| Submission No. | | | 316 | |
| Organisation Name or Name of Submitter | | | WORK Residents Association / Michael Griffin (26 Osprey Avenue, Templeouge) | |
| Case Reference NA29N.314724: Estuary through Swords, Dublin Airport, Ballymun, Glasnevin and City Centre to Charlemont, Co. Dublin. | | | | |

TUNNEL ALIGNMENT
SAINT STEPHEN'S GREEN – CHARLEMONT
RO APPLICATION VS DEEPER VERTICAL ALIGNMENT OPTION

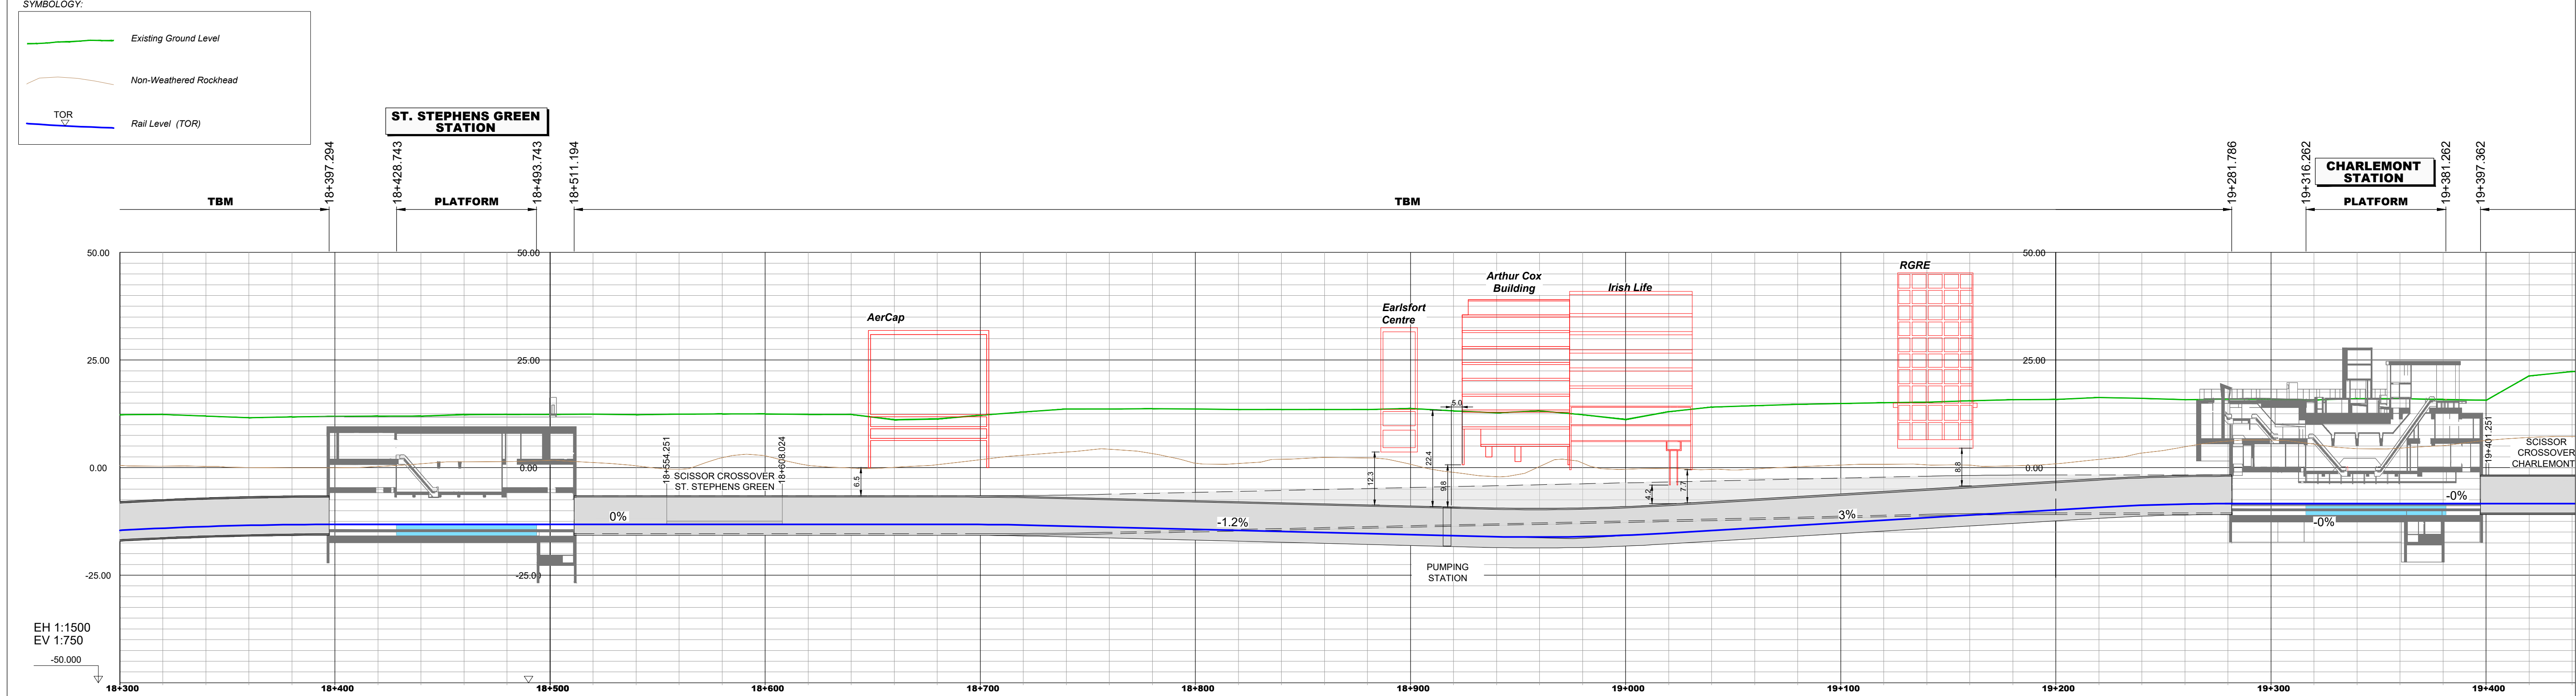
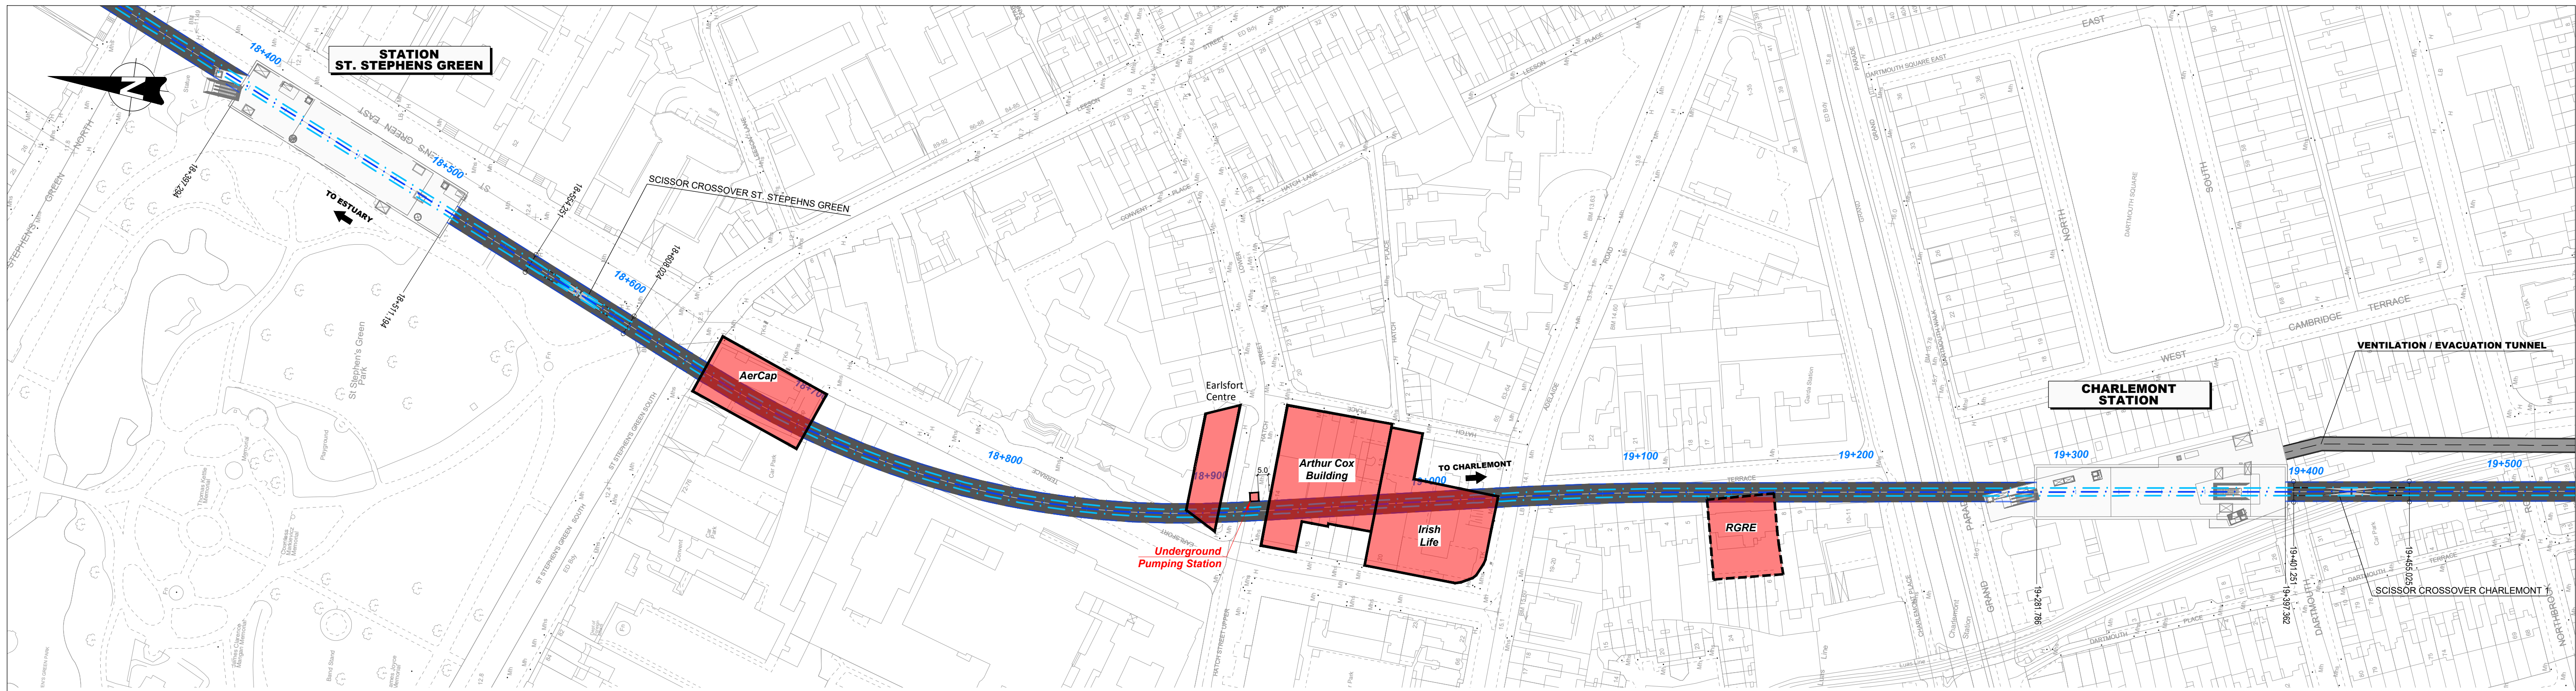
| 6 | 2. Charlemont terminus - its limitations for radial extensions to other areas of the south city | 3 | WORK Residents' Association submits that locating the Metro Link terminus at Charlemont and boring a tunnel as far as Manders Terrace seriously compromises the ability for an extension at some future time to serve the many communities in Harold's Cross, Terenure, Kimmage, Crumlin, Perrystown, Greenhills, Willington, Orwell, Templeogue, Firhouse and Knocklyon. | Please refer to response item (2) and (4) above in relation to continuation of the Project to Charlemont. As noted, the selection of Charlemont Station does not preclude onward extensions to the south or south-west of the city. As noted by the GDA Transport Strategy 2022-2042, section 12.3.2, "Charlemont offers the optimal location for the primary interchange with the Green Line in response to growing demand in the longer term and is an appropriate location to facilitate any potential future metro extensions to serve the south west, south or south east of the city region should sufficient demand arise.' Any future extensions to MetroLink will be subject to full optioneering, planning, design and appraisal and will require approval from An Bord Pleanála. |
